**WEST SUSSEX COUNTY COUNCIL
STRATEGIC PLANNING CONSULTATION**

**TO: Arun District Council
FAO: Mr D Easton**

**SUBJECT: LU/264/17/PL
Land at Fort Road, Littlehampton, BN17 7QU
Extension to existing office unit and storage area**

Block Plan. Scale 1:500

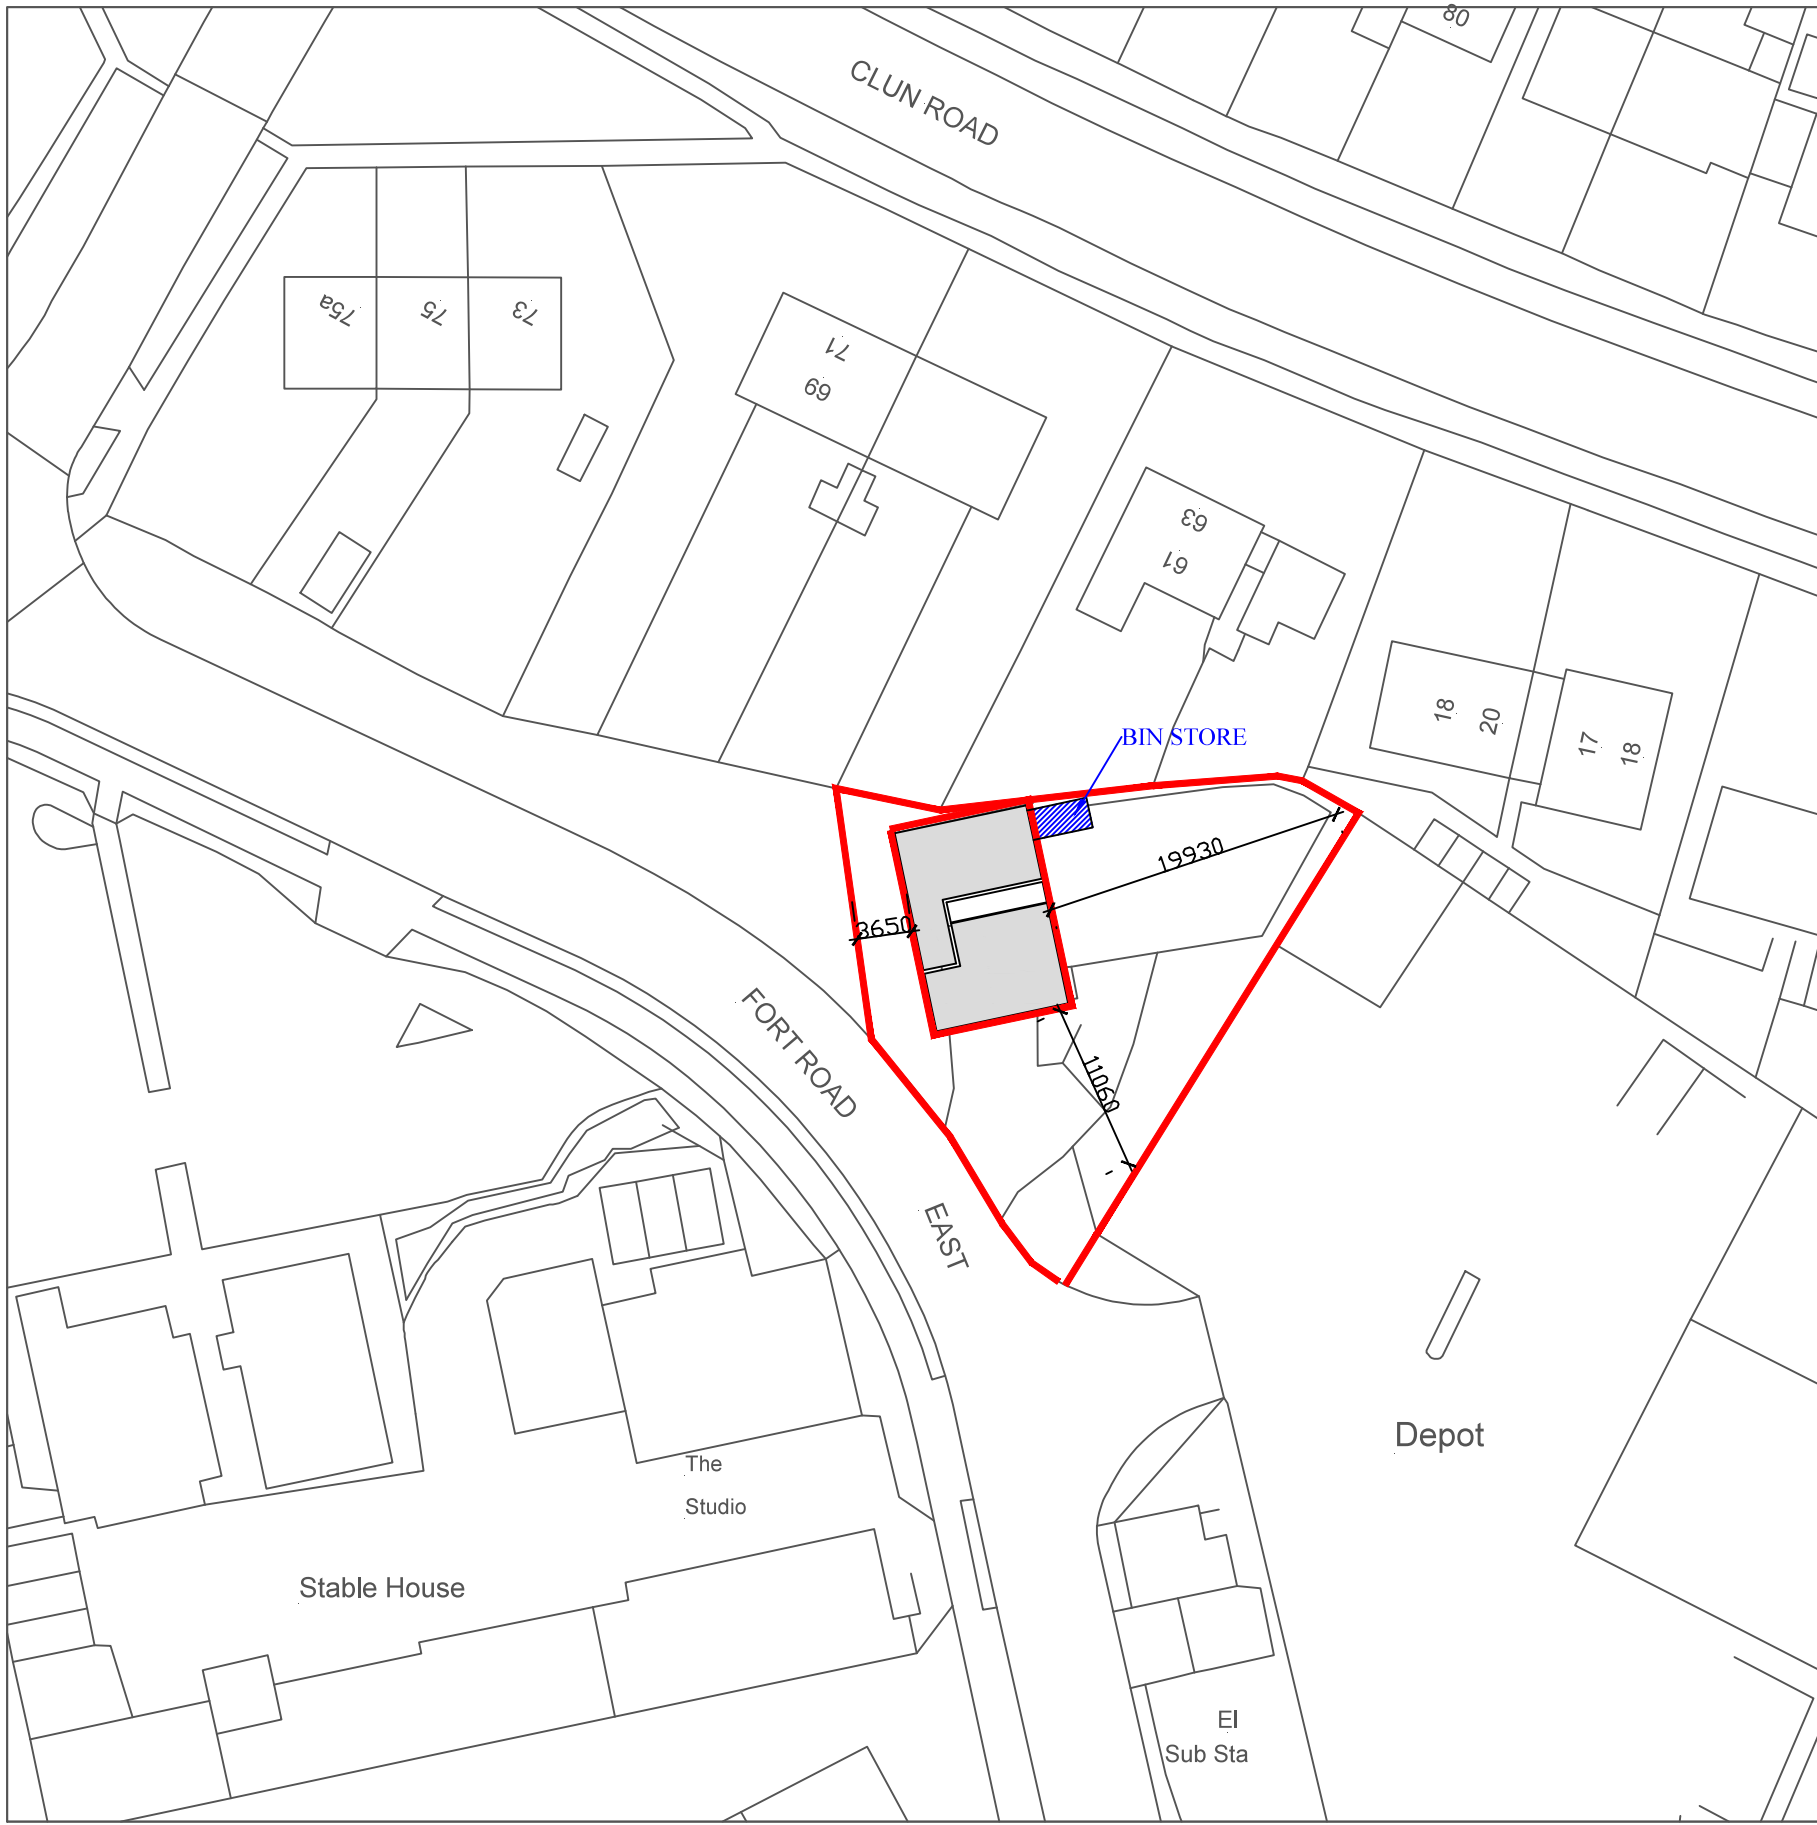
WSCC car parking standards for B1 use class is 1 space per 30sqm, which would provide 5 spaces. No parking details have been provided in the application form and these need to be included to ensure parking can be accommodated for the use.

Fort Road East is described as industrial backing onto residential properties. The road has enforceable parking restrictions along both sides of the road and therefore any staff parking should be contained where possible in the site. In terms of sustainability the site is well located close to rail and bus services. Cycle storage should be considered to promote sustainable travel as per the NPPF guidelines.

No part of the development shall be first occupied until the car parking spaces have been constructed in accordance with plans and details submitted to and approved in writing by the Local Planning Authority. These spaces shall thereafter be retained at all times for their designated use.

No part of the development shall be first occupied until covered and secure cycle parking spaces have been provided in accordance with plans and details submitted to and approved by the Local Planning Authority.
